## Cork Line Level Crossings Road Safety Audit Stage 1

Iarnród Éireann

Rev. P02

Project No: 32111000  
Document Title: Cork Line Level Crossings – Road Safety Audit Stage 1  
Document No.: 32111000/CLC/RSA01, Revision 1  
Revision: P02  
Date: September 2019  
Client Name: Iarnród Éireann

Figure 2.5: XC201 Thomastown Proposed Route Alignment

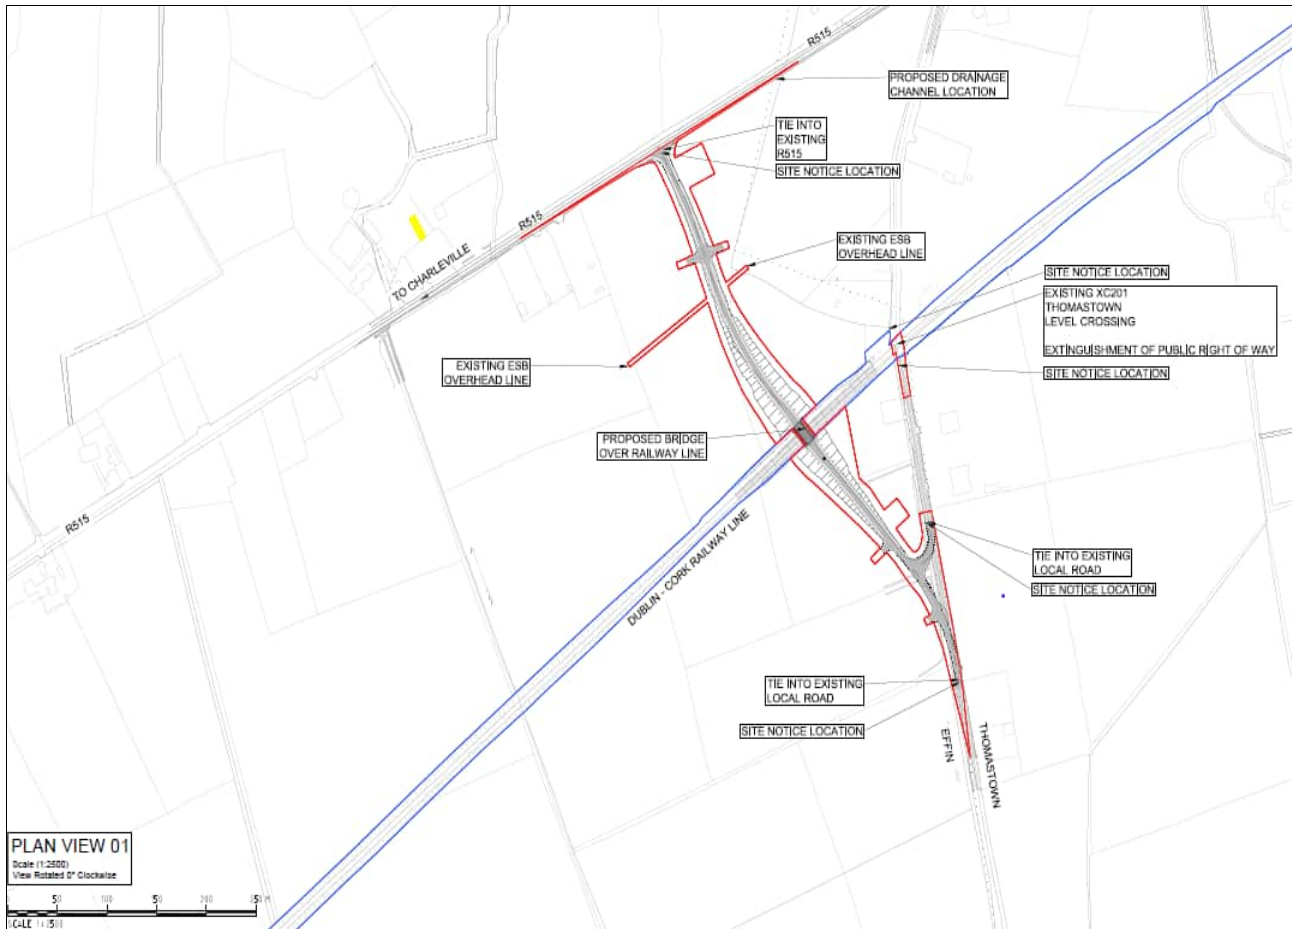
The Audit Team are concerned that the junction ahead warning sign is in close proximity to the junction itself which will lead to an increased risk of late braking and rear shunt type collisions or loss of control type collisions

It is unclear from the drawings whether warning signage is proposed on the R515 to highlight the presence of the new junction. There is the risk that existing signage relating to the location of the existing R515/ L8572 junction may cause driver confusion.

It is noted that the new road will split existing farm land, it is unclear from the drawings provided whether the fields will be accessible following the closure of the existing road. The introduction of new accesses particularly may lead to poor visibility splays and an increase risk of side impact type collisions.

At the southern tie in point between the old road and the new road there is a T junction. No details are provided of a warning sign to inform drivers, this could result in overshoot type collisions or side impact collisions, if a driver is not expecting vehicles from either direction.

The warning sign should be located in advance of the junction in accordance with the Traffic Signs Manual.

The design team shall ensure that existing signage is relocated on the Regional Road R515 in advance of the proposed new junction.

The design team should ensure that field accesses are provided where appropriate and that field gates are set back from the carriageway edge.

It is recommended that a T junction sign W016 is provided along with the STOP sign which is shown in the drawings.

Figure 2.7: XC209 Ballyhay CCTV Upgrade

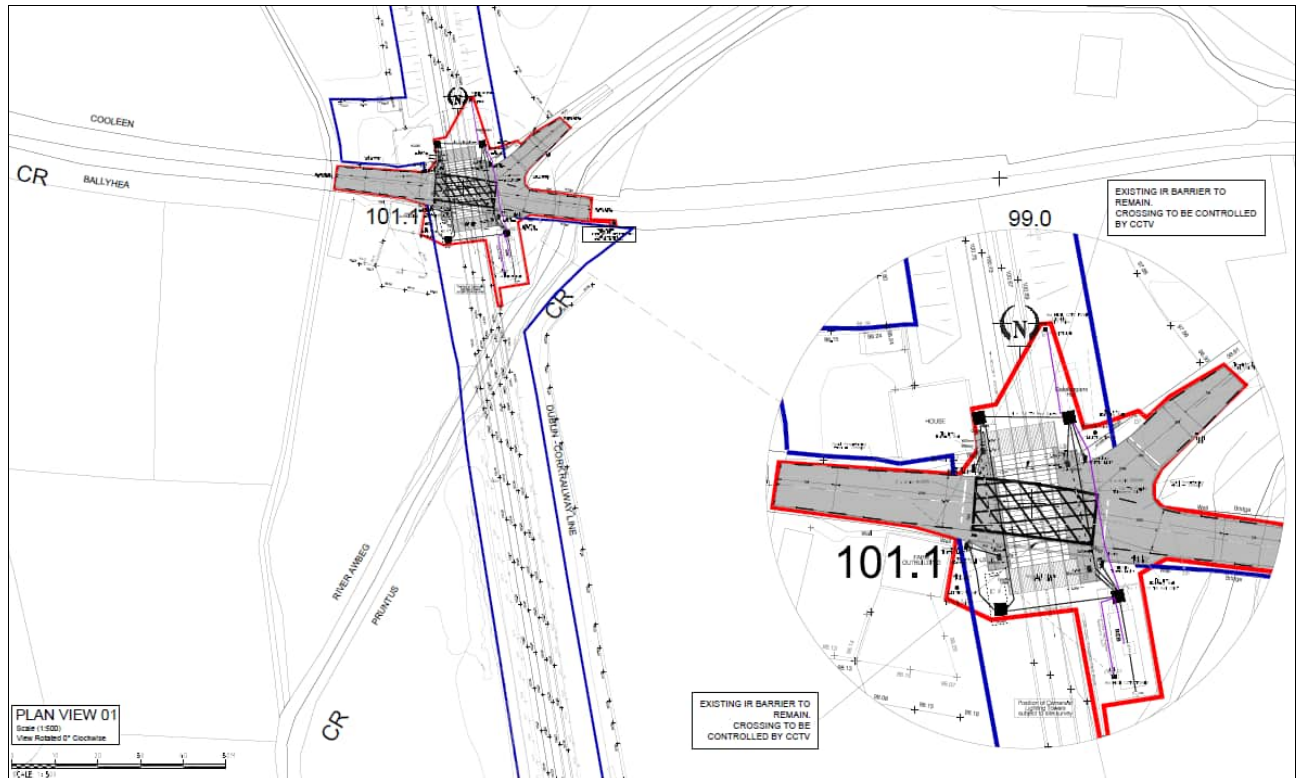
The Audit Team note that the horizontal alignment, combined with vertical alignment and superelevation of the Connector South road is below desirable minimum standards for 42kph Design Speed. The Audit Team is concerned that the new alignment, will be unfamiliar to motorists in the absence of any warning signage this could lead to loss of control type collisions

The Audit Team are concerned that the proposed tie in of the Connector South road may not tie in with the existing alignment leading to an increased risk of loss of control type collisions

The Audit Team are concerned that the proposed alignment of the main road either side of the rail bridge may result in hidden dips limiting forward visibility of oncoming traffic and leading to an increased risk of head on type collisions.

It is noted that an access is proposed at Chainage 100 on the main road and Chainage 290 on the Connector Road. It is unclear from the drawings provided whether all remaining fields will be accessible following the closure of the existing road. The introduction of new accesses, particularly on the inside of bends may lead to poor visibility splays and an increase risk of side impact type collisions.

The Audit Team are concerned that the proposed passing bays on are not sufficiently long enough to facilitate a tractor/ trailer which would prevent two vehicles passing one another and result in a risk of vehicles having to reverse on the narrow road.

The Design Team should provide advance warning signage and Chevron Boards to guide the driver around the Connector South Road's sharp changes of direction.

The Design Team shall insure that the proposed alignment ties in with existing.

The design team should review the vertical alignment with a view to removing any hidden dips.

The design team should ensure that field accesses are provided where appropriate with adequate visibility splays and that field gates are set back from the carriageway edge.

The design team shall ensure that passing bays are provided in accordance with DN-GEO-03030.

Figure 2.9: XC211 Newtown Proposed Alignment

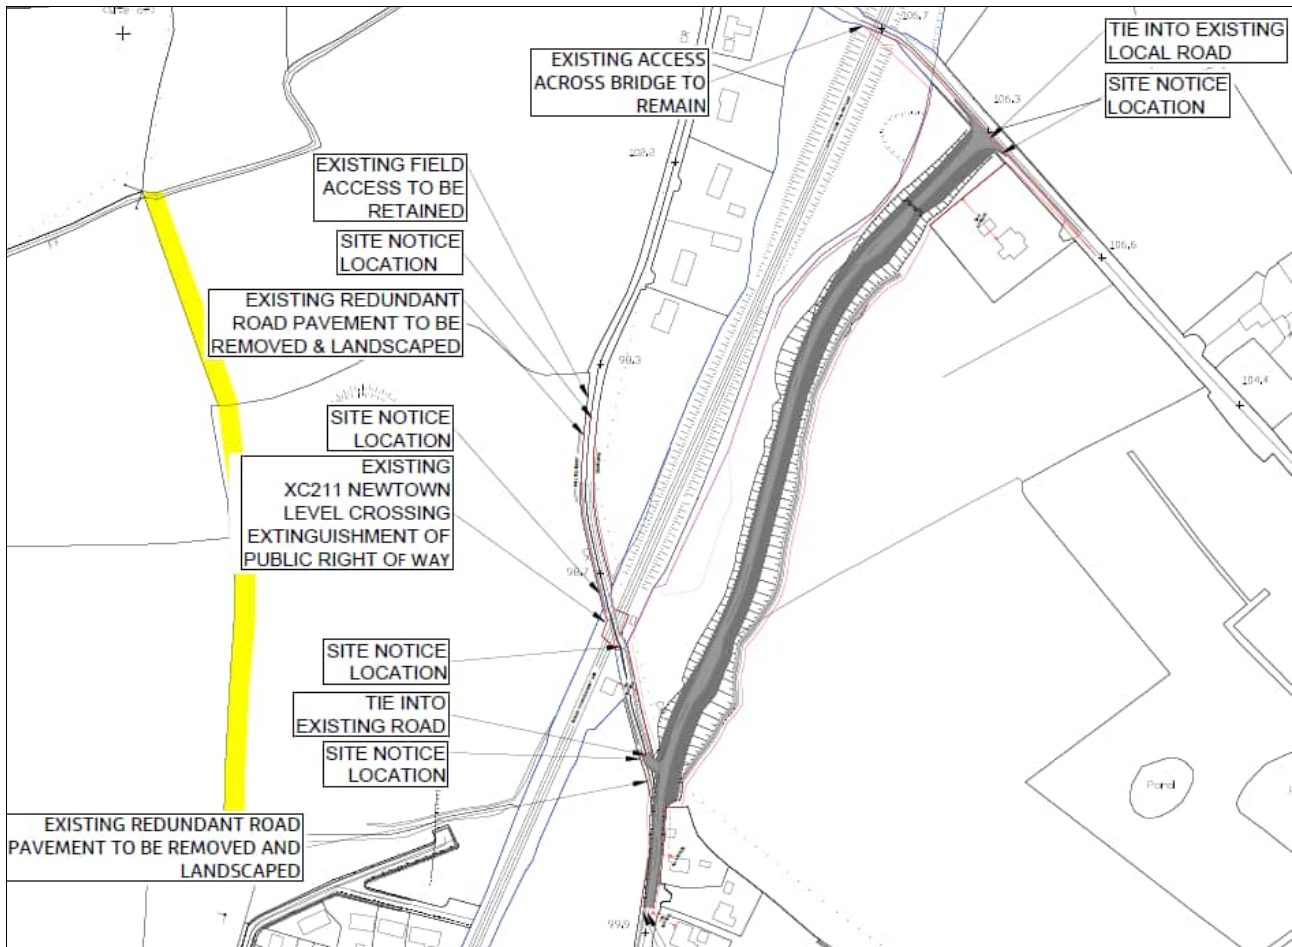
The Audit Team is concerned that between chainage 0+280m and 0+470m, the steep vertical alignment combined with the crest curvature one step below desirable minimum and a 4.0m width carriageway may result in vehicles having to reverse to the passing bay at chainage 0+250m which may lead to a loss of control type collisions.

The Audit Team is concerned that motorists unfamiliar with the new layout, will be unaware of the closure of the level crossing with no turning head provided to allow vehicles to turn and exit. The lack of a turning head may result in vehicles having to reverse over a long distance leading to a loss of control type collisions.

The Audit Team note that a vehicle restraint system is proposed between chainage 0+300 and 0+400m on the eastern side of the proposed realigned local road. The Audit Team are concerned that the vehicle restraint system will impinge upon the forward stopping sight distance on the inside of this bend leading to an increased risk of head on collisions.

The Audit Team note that "Road Narrows on both sides" and "Left Bend Ahead" Warning Signage is provided in advance of the rail overbridge. Its unclear from the drawings whether these warning signs will be retained. There is the risk that motorists will be unaware of the road layout ahead if they are removed.

The Audit Team note that the existing L5535-0 is narrow in width and on-site observation indicate rutting of the existing verge. It is assumed this is to facilitate vehicles passing one another. The proposed realignment will generate an increase in traffic along the L5535-0 exacerbating this situation and lead to detritus on the carriageway resulting an increased risk of loss of control type collisions.

The proposed realignment will result in increased traffic on the L5535-0 and utilisation of the existing narrow rail overbridge. The Audit Team are concerned that the existing forward visibility approaching the existing rail overbridge is compromised by existing vegetation, leading to an increased risk of head on type collisions.

The Audit Team note that at the junction of the L5534-0 and L5535-0, the road surface is poor and road markings are faded. In addition, a Yield sign is located at the junction resulting in an increased risk of motorists overshooting the junction.

This design team should consider provision of an additional passing bay between chainage 0+370 and 0+470m.

The design team shall provide a turning head at the end of these proposed cul de sacs. A F 350: Cul-de-sac sign shall be provided in accordance with the Traffic signs Manual at the entrance to each local road.

The design team shall insure the VRS is sufficiently set back so as to not impact upon the forward stopping sight distance.

The warning signage should be retained, and the design team shall consider including Supplementary Plate P 060 – “Oncoming Traffic” to provide further warning of the road layout ahead due to the narrow carriageway/ road overbridge.

The Design Team should consider the provision of a formal hardstanding area on either side of the overbridge to allow vehicles to pull in off the L5535-0 and allow other vehicles to pass.

The existing vegetation is removed to improve forward visibility of the overbridge.

The design team shall highlight the issue to Cork County Council for resolution. It is recommended that the “Yield” sign is replaced with a “STOP” warning sign.

Figure 2.11: XC212 Ballycoskery Proposed Alignment

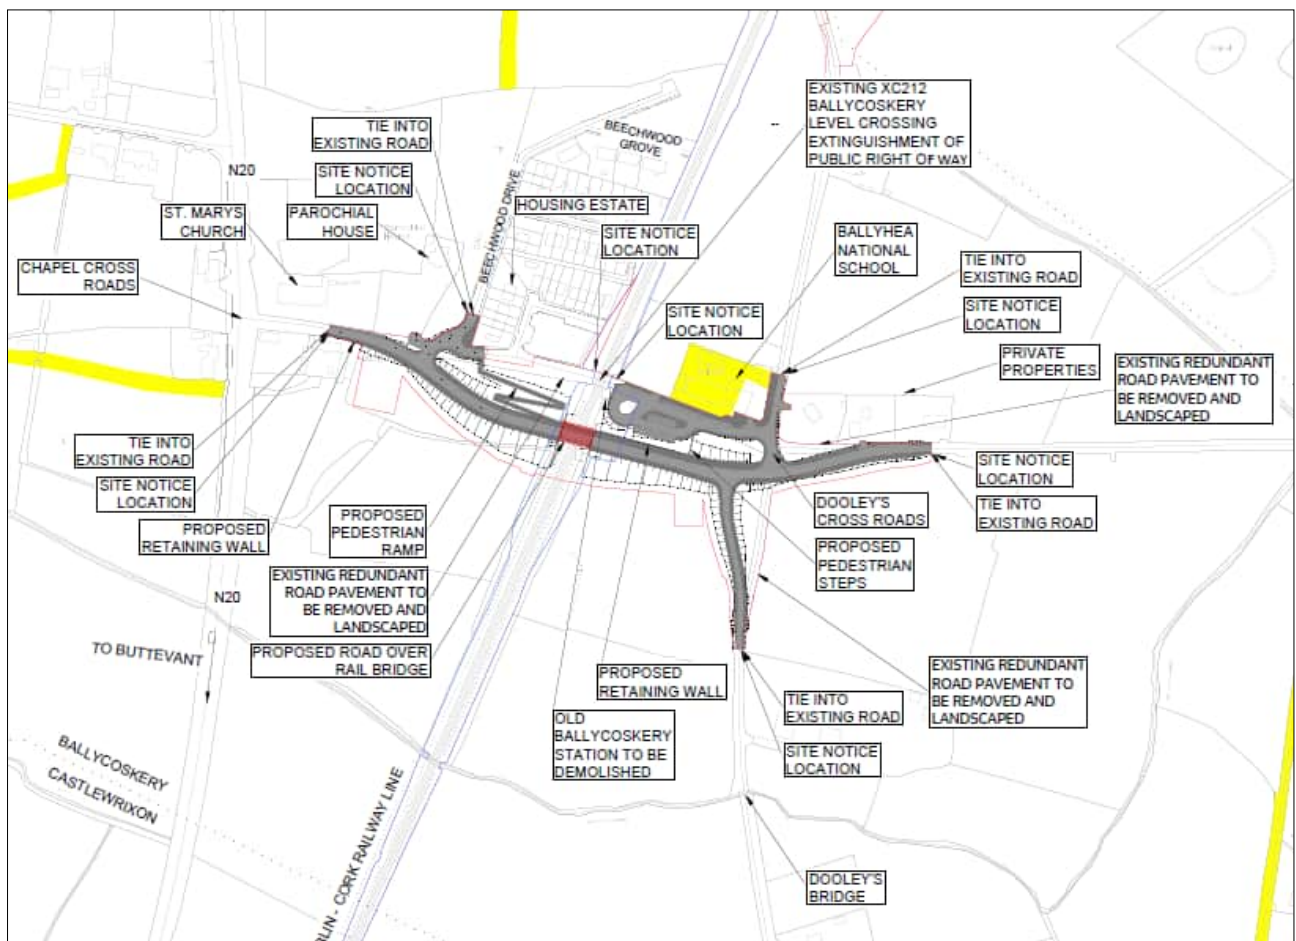
There is a proposed pedestrian crossing on the access road to the school, no details are provided as to whether this crossing is controlled or uncontrolled, buff tactile paving indicates this an uncontrolled crossing, but appears to look like a Zebra crossing. Confusion over who has priority could result in pedestrians stepping out in front of vehicles.

The proposed new road alignment removes the existing access near the school to the Newtown Level crossing as this road will become a cul-de-sac. Drivers wanting to travel north do so via the new road alignment via Beechwood Drive. No signing is proposed to inform drivers of the change in route, therefore drivers could travel in the direction of the school, realise the road is closed and perform a turning manoeuvre potentially in front of the school.

The proposed 2m footpath (2.6m footpath on overbridge) links the school to the local residential areas. No details are provided for facilities for cyclists. If there is a demand for cycling on these paths, insufficient widths could result conflict between different users.

The Audit Team are concerned that a desire line may exist along the realigned road that may result in pedestrians walking along the northern verge to reach the footpath at the bellmouth on Beechwood Drive. This may result in an increased risk of trips and falls.

It is recommended that a controlled crossing is installed due to the proximity of the school.

It is recommended that advanced directional signs are introduced, to reduce the number of vehicles incorrectly travelling in the vicinity of the school.

The design team should consider if there is a demand for a shared use facility and whether the footpath should be extended along the realigned L1533.

The design team should consider if there is a demand for a footpath/ shared surface along this section.

Figure 2.13: XC215 Shinanagh Proposed Alignment

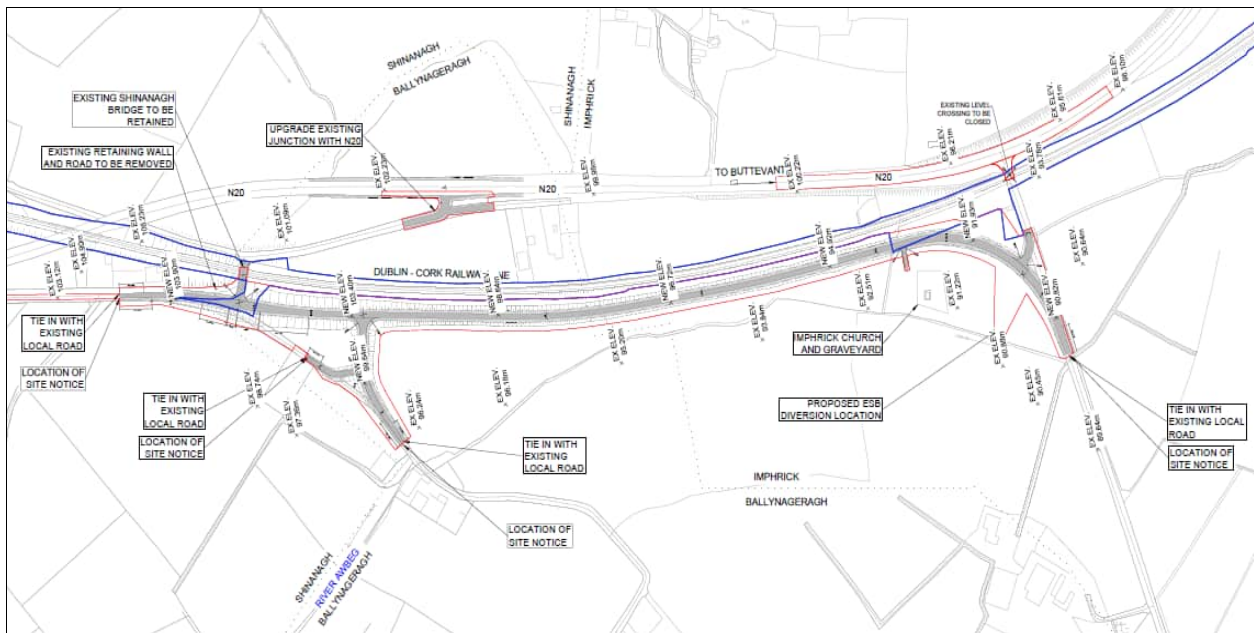
Where the existing road (L1320) ties in with the new road the road deviates to the left, with a junction to the right for a field access. Drivers unfamiliar with the new layout may become confused and take the right turn to gain access onto the N20.

On the N20 the junction for the L1320 will be closed as there is no longer access, there is exiting left turn deacceleration lane and right turn pocket as well as associated signs. Drivers on the N20 could mistakenly try and turn in to the old junction, resulting in them being in conflict with other road users.

The access over the rail line will result in the existing westbound approach to the structure being reconfigured. On site the RSA team observed that the Road Restraint System (RRS) had P1 ramped terminals, which could result in a vehicle becoming airborne and flipping over.

There is an existing public house with parking bays that front the highway as well as a car park, the Audit Team are concerned that with the removal of the on-street parking and introduction of the verge that drivers will still park on the road, reducing the width of the carriageway, this could result in side swipe or head on collisions.

The Audit Team are concerned that a Side Road Ahead (left) warning sign is used at a number of locations on the proposed layout as opposed to a T Junction ahead or Side Road Ahead (right) warning sign which may lead to an increased risk of driver confusion.

Install advanced direction signs / chevrons on both approaches on the main road to highlight the direction of travel.

The design team must ensure that all existing road markings and signs are removed and ensure the new junction is clearly signed and marked on the N20.

It is recommended that the terminations on the new RRS barrier will have P4 (flat) terminations.

The Design Team shall ensure that the proposed alignment ties in with existing and that the access to the car park is retained and consider the introduction of parking restrictions.

It is recommended that junction warning signs are provided in accordance with the Traffic Signs Manual.

Figure 2.15: XC219 Buttevant Proposed Realignment

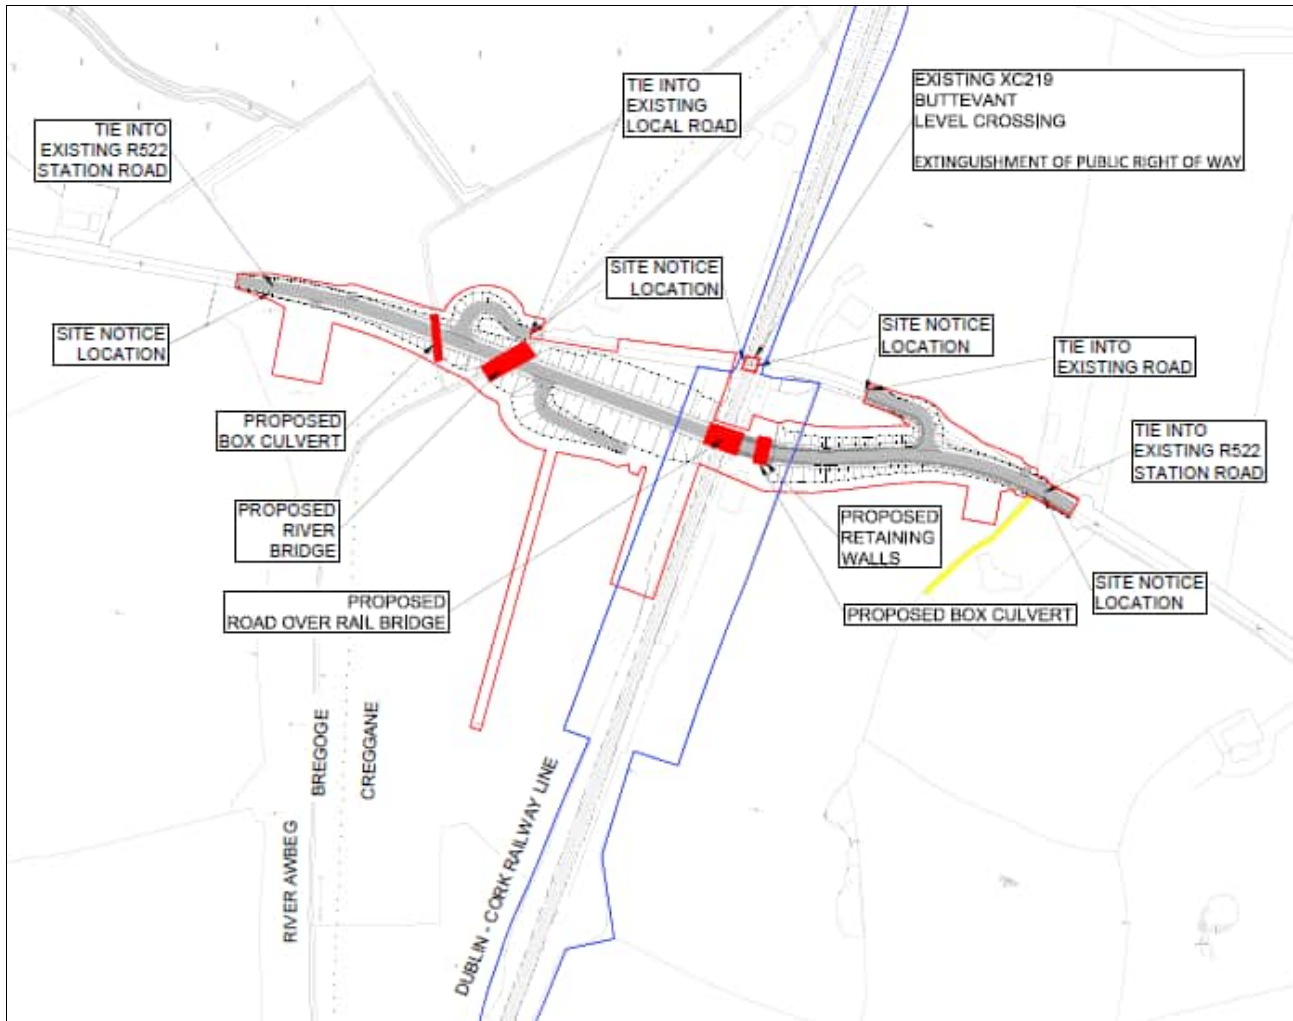
On the drawing there is a staggered road junction indicated. One side road connects to the existing road, providing access to a property, while the other access appears to be a private access to a field. A driver could mistake the farm access for a side road, resulting in them correcting an unnecessary manoeuvre which could lead to conflict with other road users.

Where the new road alignment ties in with the existing road to the eastern extent of the scheme, there is a proposed footpath. This ties in with the existing footpath on southern side of the carriageway, which is currently street lit.

The proposed footpath terminates on southern side of the carriageway and continues a short distance down a new side road to the northern side of the carriageway. Pedestrians could find themselves crossing on a bend, which could result in them being in conflict with vehicles if there is insufficient forward visibility.

It is recommended that junction warning signs are provided in accordance with the Traffic Signs Manual.

The design team need to ensure there is adequate visibility to safely allow pedestrians cross the road. The design team should ensure that public lighting is provided along the footpath.
